## Parks and Wildlife

August 12, 2020

Re: Grandview Reserve Sketch Plan

SHEET
 SP1.2
 2

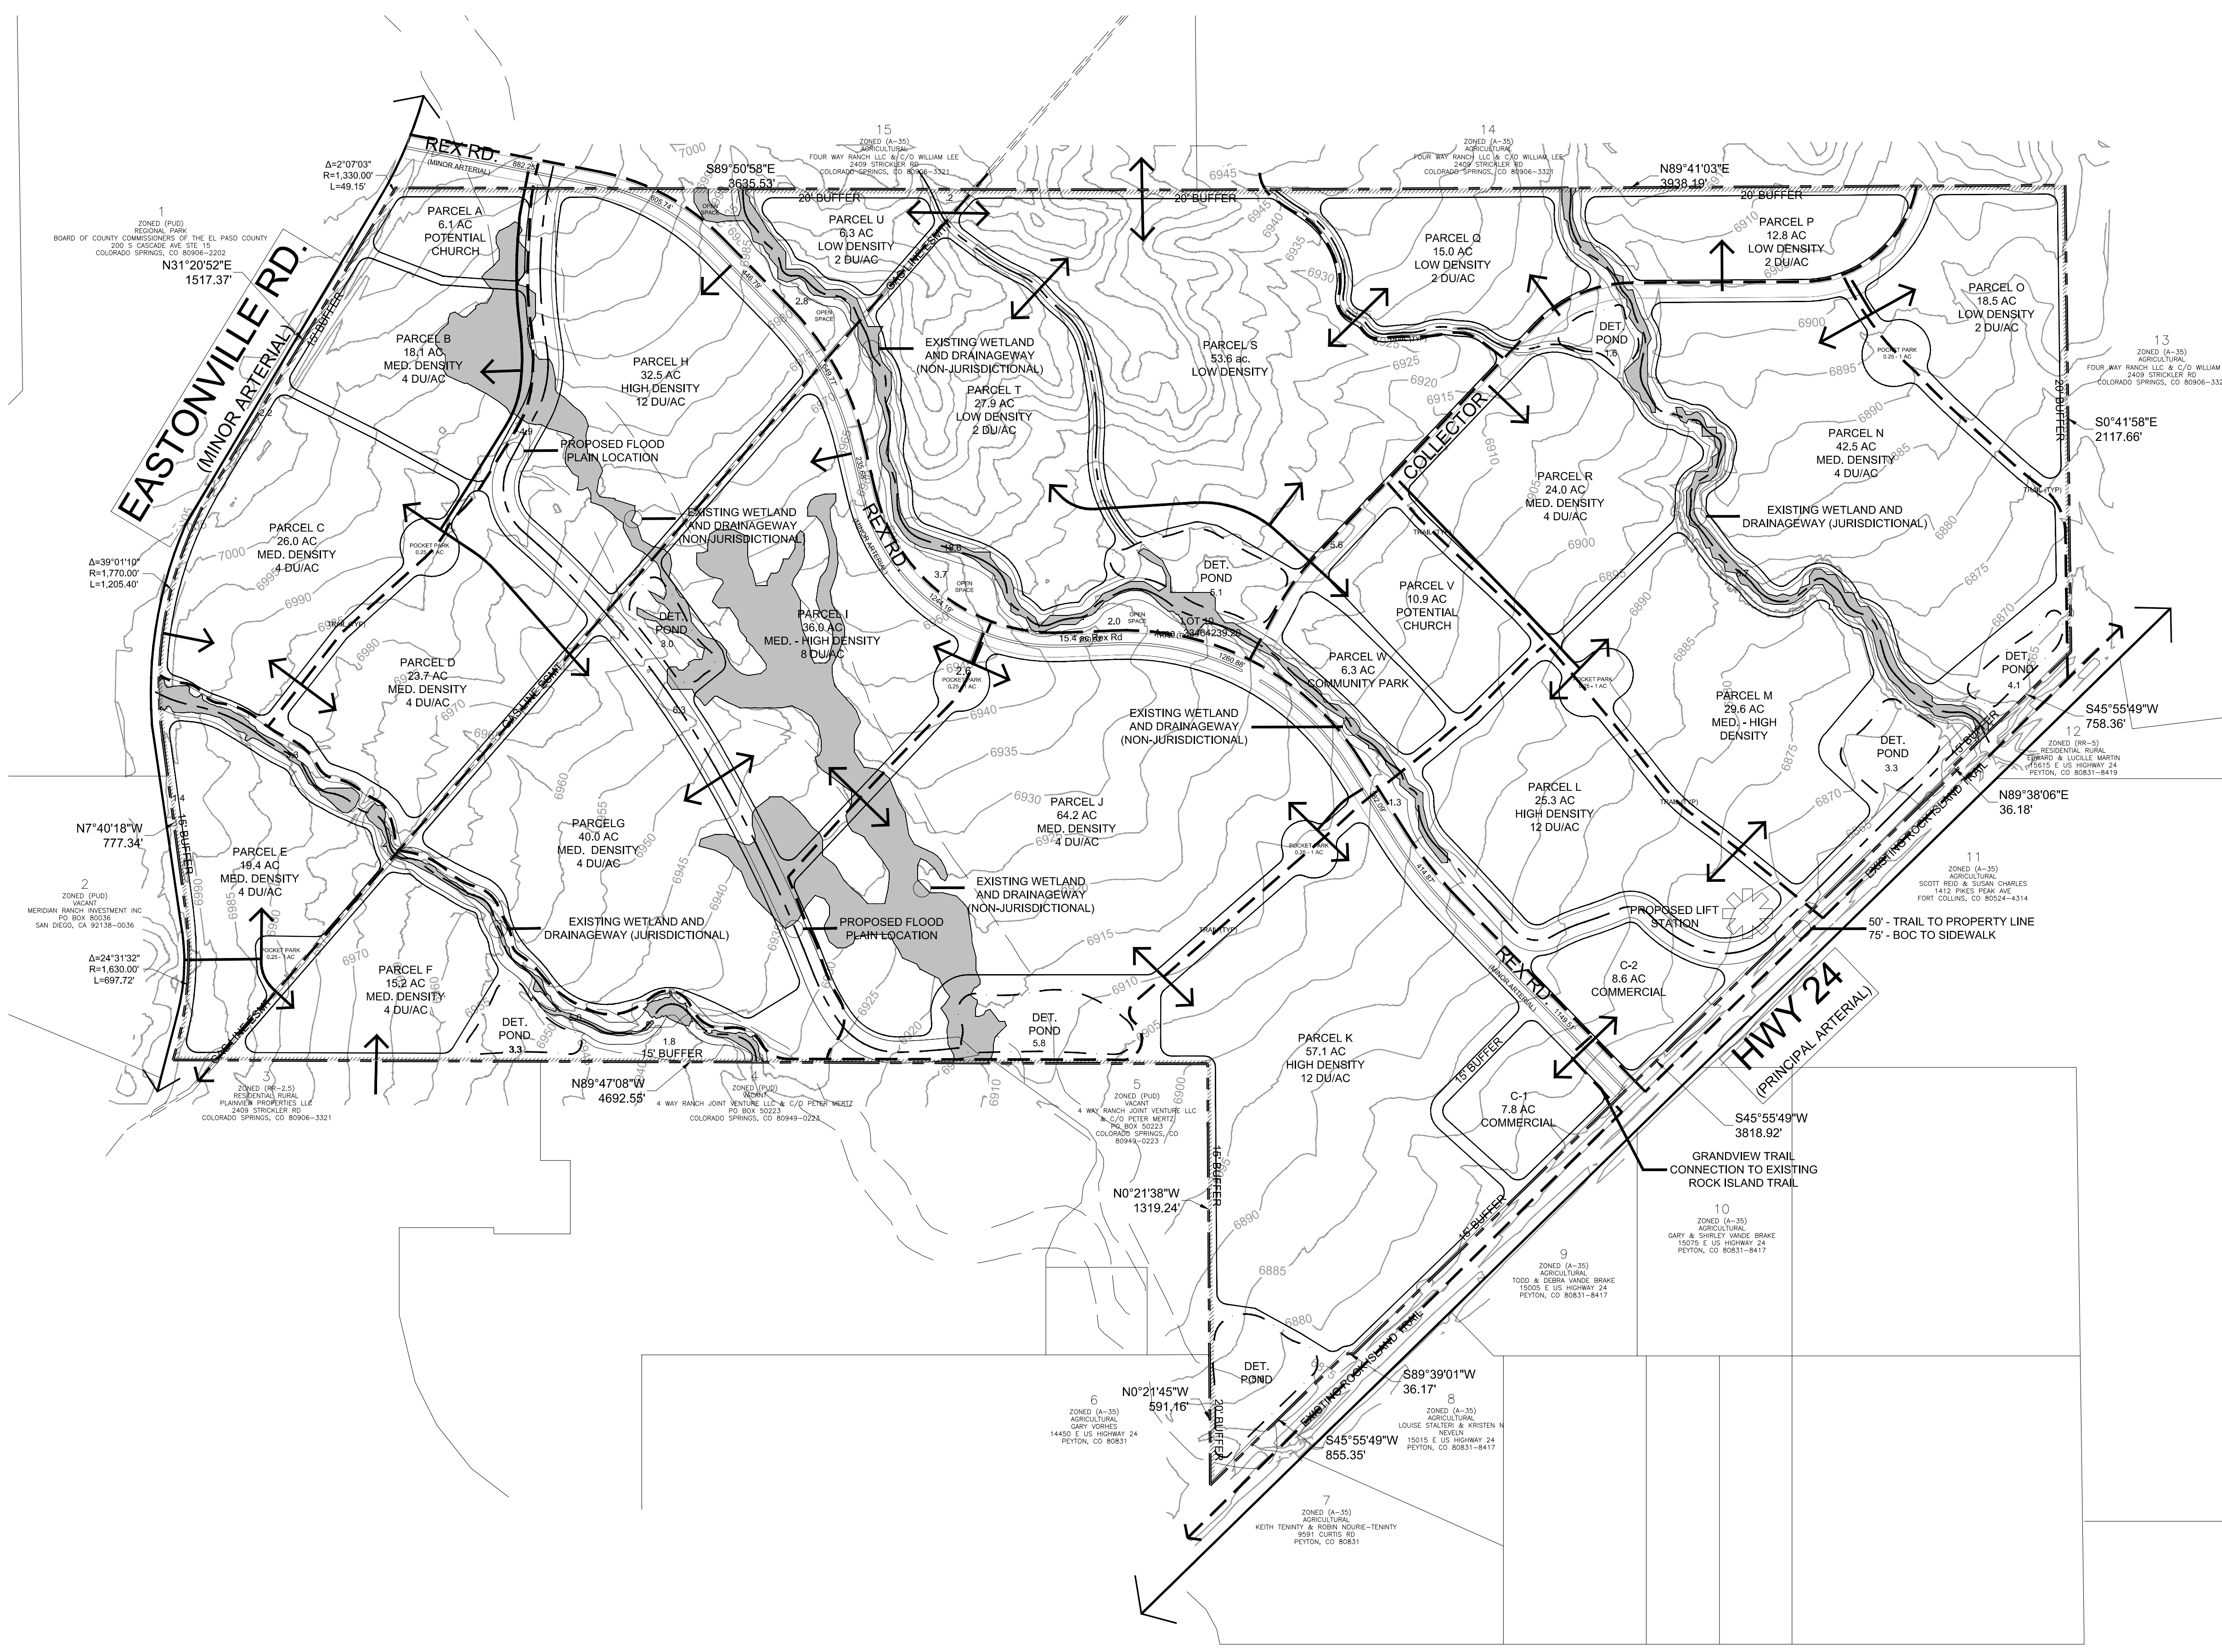
CPW recommends crossing any riparian corridors and streams at a perpendicular angle, in order to reduce impacts to natural resources, as well as spanning the corridors with structures located outside the riparian and stream zone. During construction, stream crossing by construction vehicles should be avoided. CPW requests that any new service roads that are proposed for construction in conjunction with the project avoid crossing creeks or stream beds to avoid impacts to wildlife and habitat. If any new access or maintenance roads will be constructed that cross stream habitat, CPW would like to be consulted on best management practices and options for construction to minimize impacts. A construction design for any new or reconstructed riparian crossing that actively minimizes barriers to fish passage at all water levels and mitigates any existing barriers where possible would minimize the negative impact of the project on native fish species.

CPW recommends a 100 foot buffer zone be permanently placed around the creeks and ponds. If a trail is constructed near the creek or ponds, it should be a minimum of 100 feet from the edge. This buffer zone will offer wildlife utilizing the creek and ponds less disturbance by development and decrease the likelihood of human and wildlife encounters. The existing native riparian vegetation around the creeks, the ponds and in the drainage ways should be kept intact for wildlife habitat and to increase ground stabilization.

viewing opportunities. CPW recommends constructing trails on the outer edges of open space areas. This minimizes wildlife disturbance and creates increased wildlife viewing opportunities. Trails near creeks and drainage areas should cross perpendicular rather than run parallel to these critical wildlife habitat areas. Crossings should occur in areas that have the least usage by wildlife in order to have minimal impacts on wildlife.
